Re: Stack Short Plat (SP22006)

Thank you for your preliminary short subdivision submittal. After technical review of the proposed short subdivision, the Planning Division offers the following comments:

RE: Stack Short Plat, File# SP22-006
5 Lot Short Plan
3807 122nd Street NE & Parcel # 30050900202200

STACK DESIGN & CONSTRUCTION, LLC
STACK SHORT PLAT
 PRELIMINARY SITE PLAN

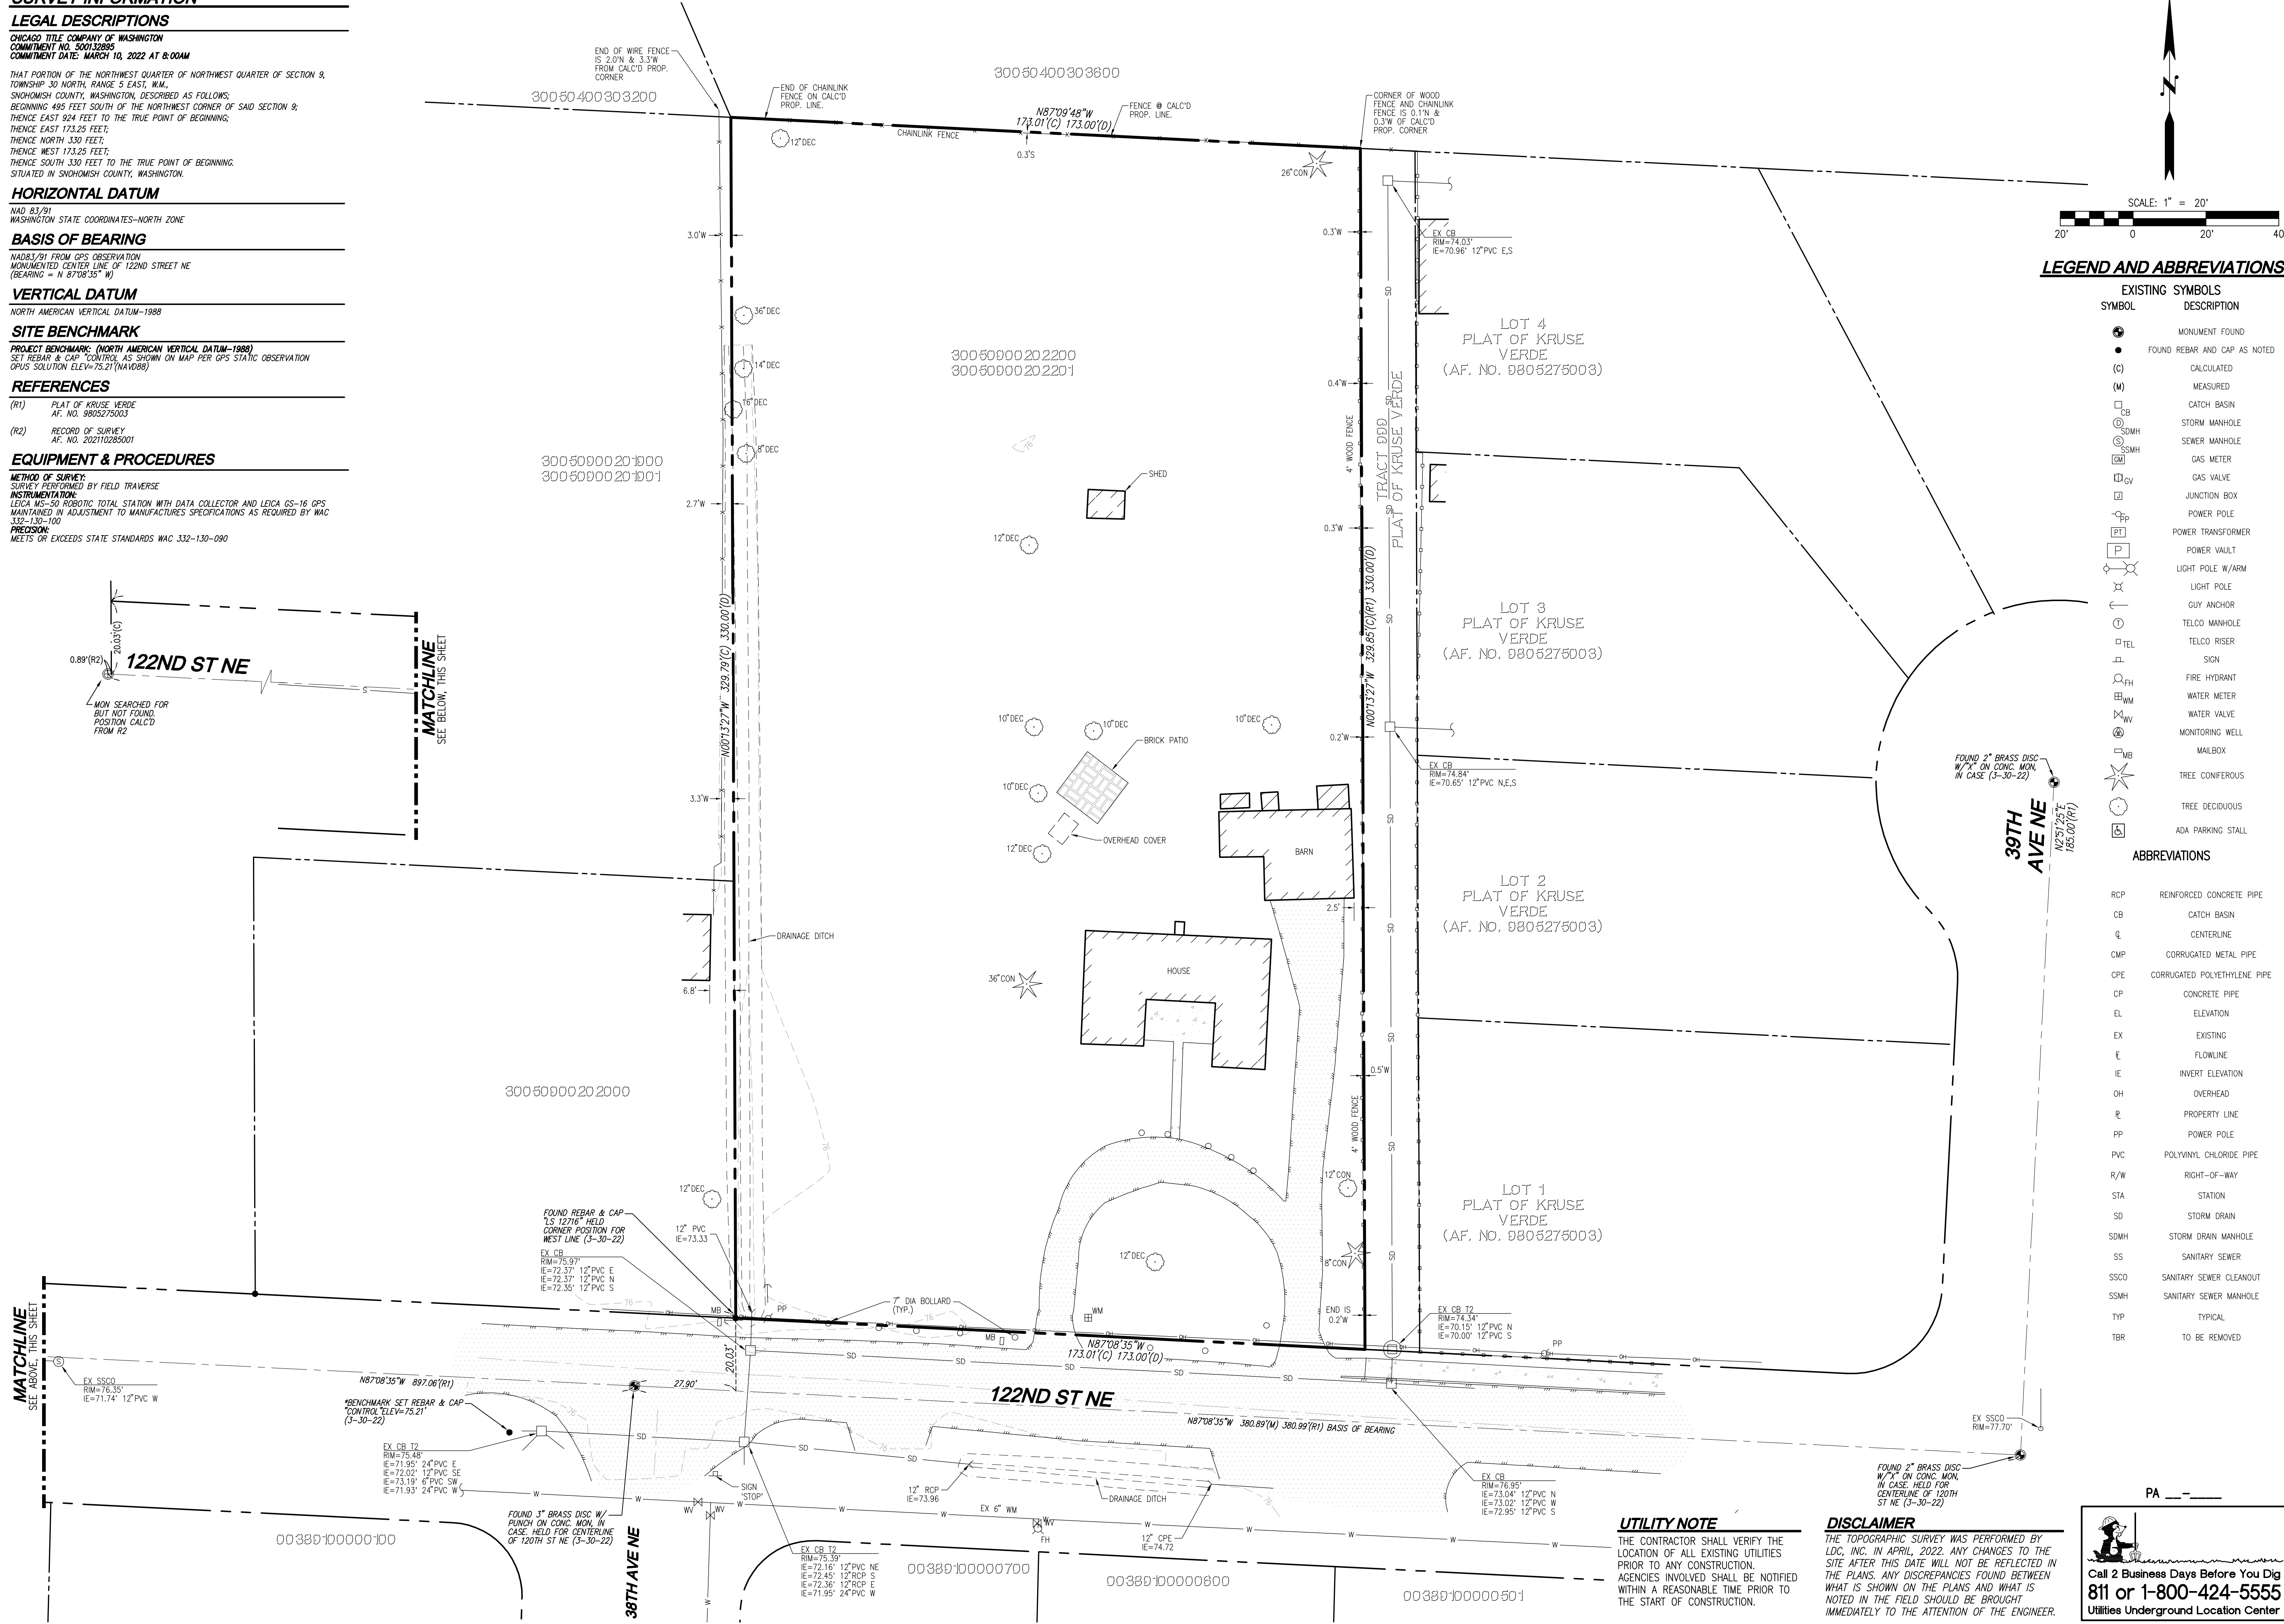
2. Please include file number SP22-006 on all future maps.
3. Revise title to 'STACK SHORT PLAT' instead of 'STACK SHORT PLAN.'
4. Add Tax Parcel 30050900202201 to 'PROJECT INFORMATION.'

5. Revise 'PROJECT INFORMATION' to include AVERAGE LOT SIZE and SMALLEST LOT SIZE.
6. Revise 'DIMENSIONAL STANDARDS' to include:
 - **Minimum lot area:** 5,000 sq. ft.

SP-01
 SHEET 3 OF 6

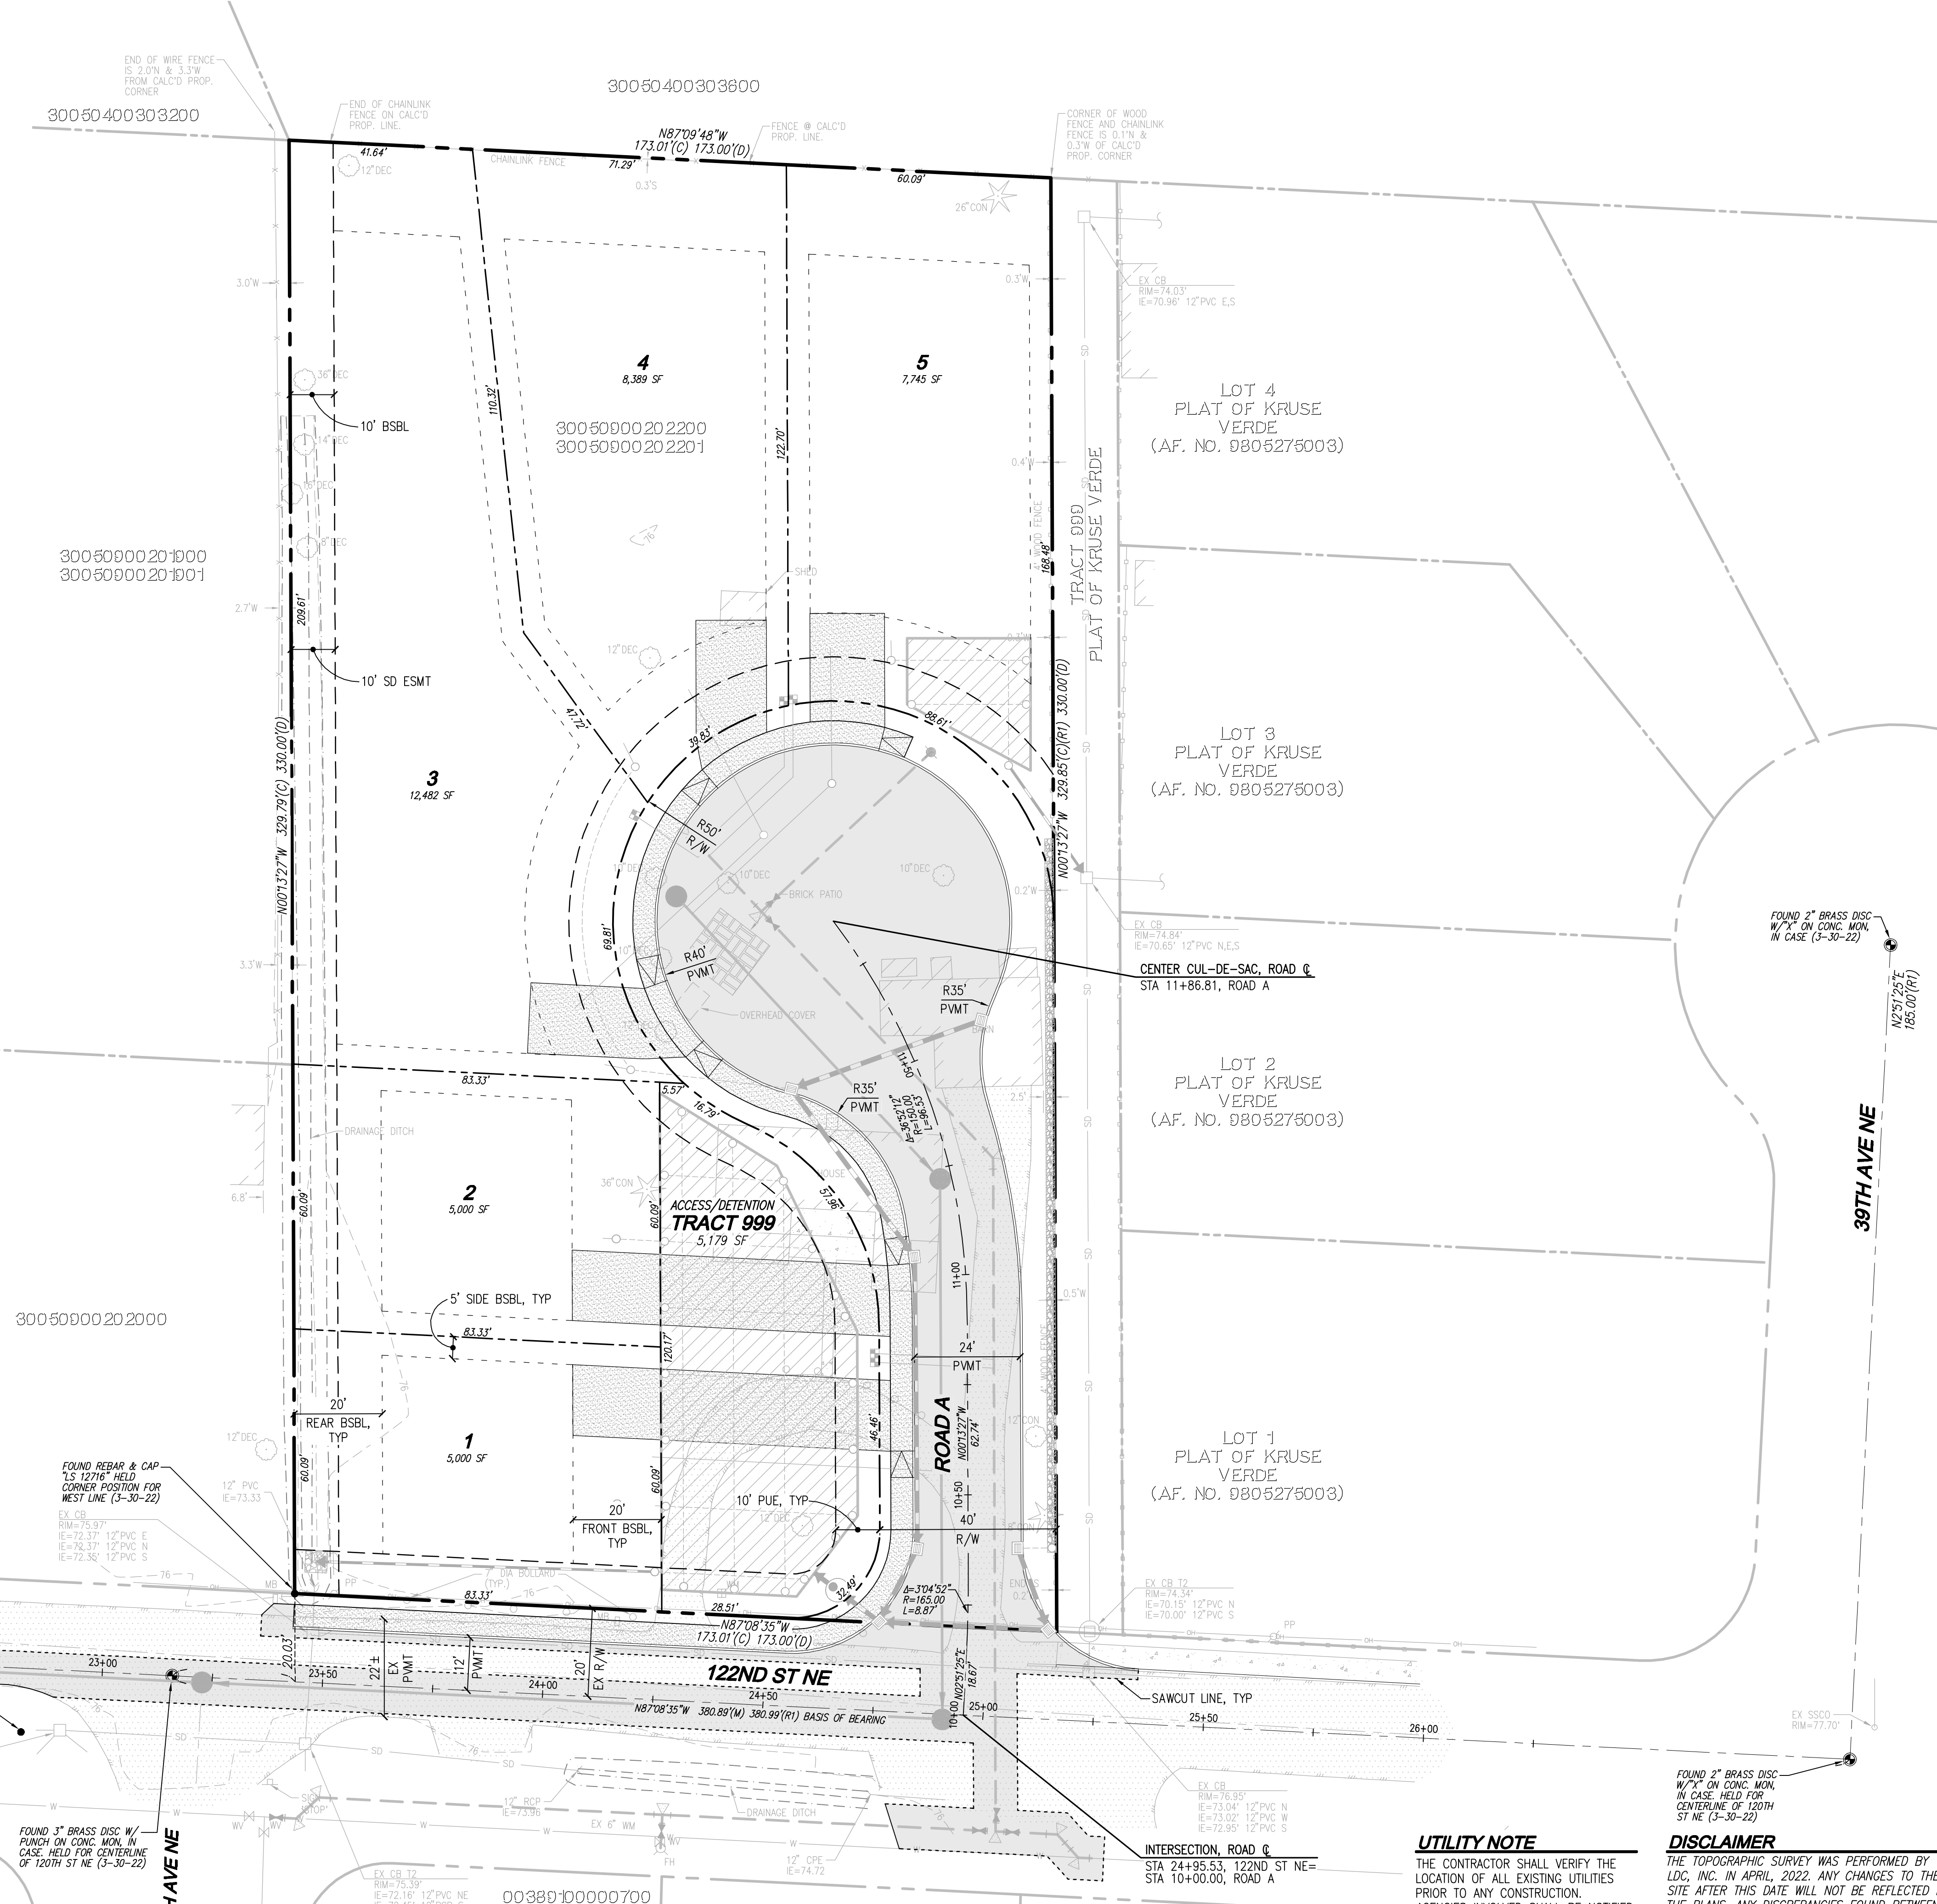
- **Minimum lot width:** 60 ft.
 - **Minimum Lot frontage on cul-de-sac, sharp curve, or panhandle:** 20 ft.
7. Lot tract road ROW and property boundary lines shall be solid lines not dashed.

8. Pursuant to the definition of "Lot Lines" outlined in MMC 22A.020.130 "Rear lot line" means the lot line opposite and most distance from the front lot line. Therefore, the rear lot line for Lot 3 shall be the west property boundary. It appears this would leave a building envelope depth of approximately 33'. Amend Sheet SP-01 to reflect the correct rear lot BSBL.

10. Tract 999 labeled as "Access/Detention" on the provided preliminary plan needs to be relocated behind Lots 1 & 2. Access for maintenance of the Tract shall come from 122nd Street NE. Revise the plans showing the tract relocation and access coming from 122nd Street.
